Maritime &
Coastguard
Agency

Hornsea Project Four Offshore Wind Farm – EN010098

Examination Timetable – Deadline 2 – Written Representation

A5.7.1 Environmental Statement Volume A5 Annex 7.1 Navigational Risk Assessment (APP-081, APP-082 & APP-083) and A2.7 Environmental Statement Volume A2 Chapter 7 Shipping and Navigation (APP-019)

**Figure 2.1** Overview of indicative layout

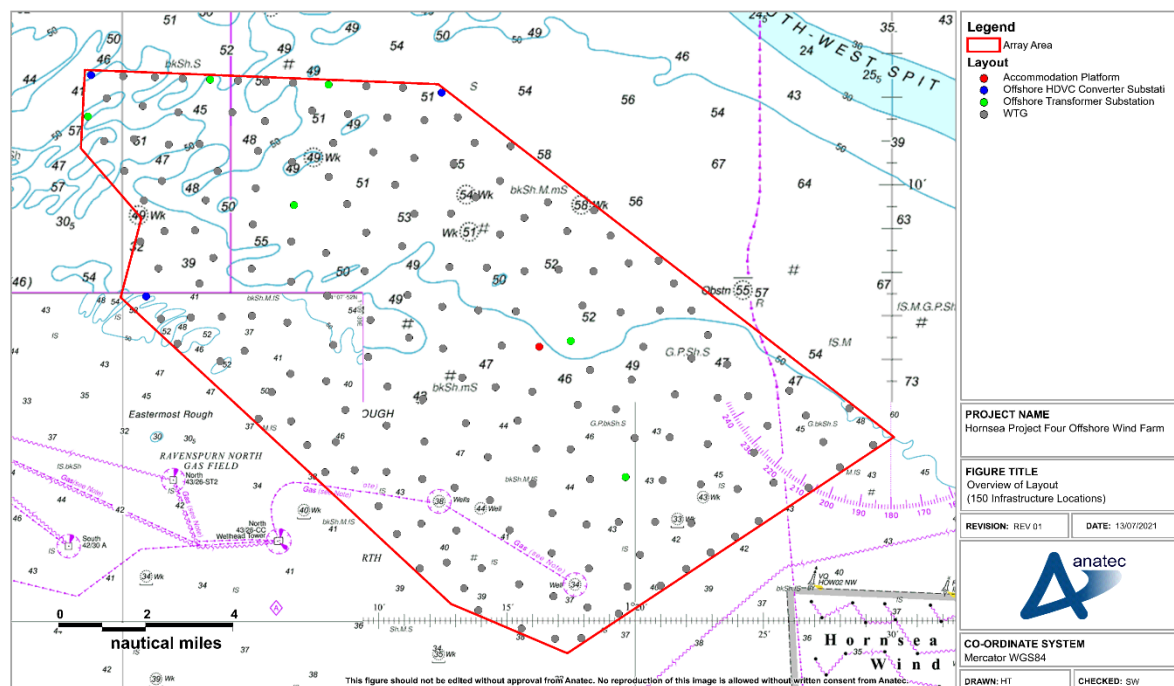
The turbine layout design will require MCA approval prior to construction to minimise the risks to surface vessels, including rescue boats, and search and rescue aircraft operating within the site. MCA will seek to ensure all structures are aligned in straight rows and columns with a minimum of two lines of orientation.

Paragraph 7.11.2.42 of APP-019 – we recognise that larger commercial vessels are less likely to plan their passage through the array, however it must also be recognised that vessels may be required to navigate within an array due to unexpected circumstances.

Paragraph 7.11.2.44 of APP-019 – multiple lines of orientation and grid layouts provide more options for safe internal navigation and SAR access. Fishing vessels may follow seabed features when actively fishing however when transiting through a wind farm we would expect the turbine positions and alignment to have more of an influence on safe navigation.
